Application for a non-material amendment following a grant of planning permission.

2018 | 0770

REAR SINGLE STORY EXTENSION TO BUNGALOW.
- REDUCTION OF SOFFIT WIDTH ON WEST FACING
WALL OF THE EXTENSION - 1.5 METRES IN LENGTH.
SOFFIT + FACIA WIDTH REDUCED FROM 27CM
TO 2CM FACIA BOARD ONLY.
PLEASE SEE ATTACHED PHOTOGRAPHS.

PROPOSED SIDE
ELEVATION

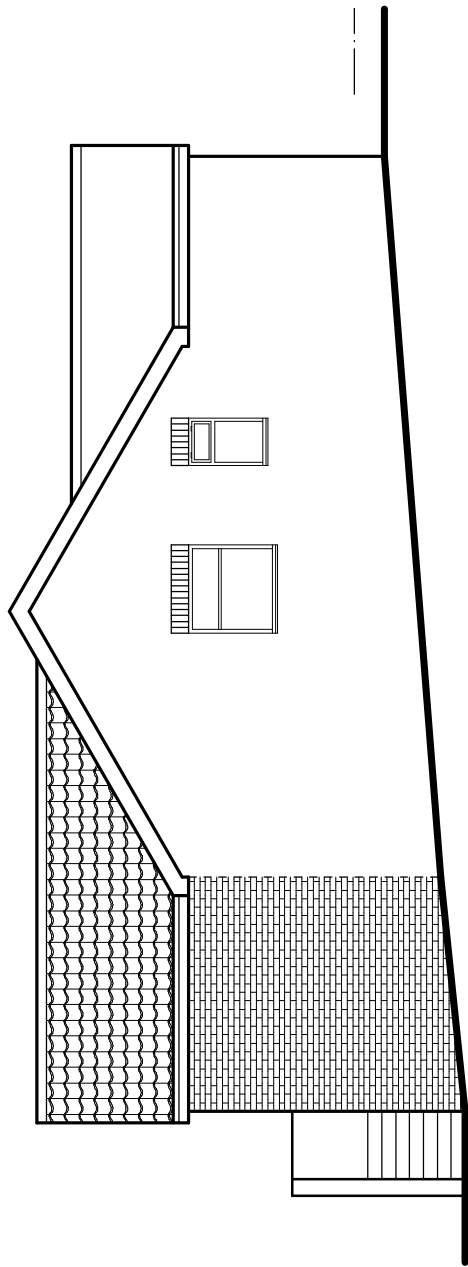
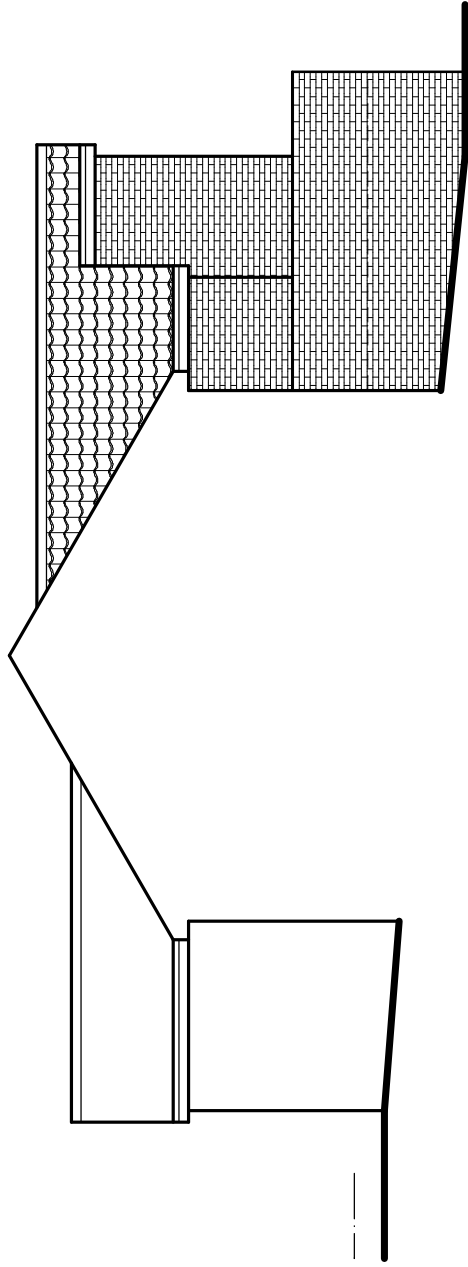
IN ORDER TO AVOID ANY OVERHANG OF
GUTTER ACROSS BOUNDARY WITH NEIGHBOUR.
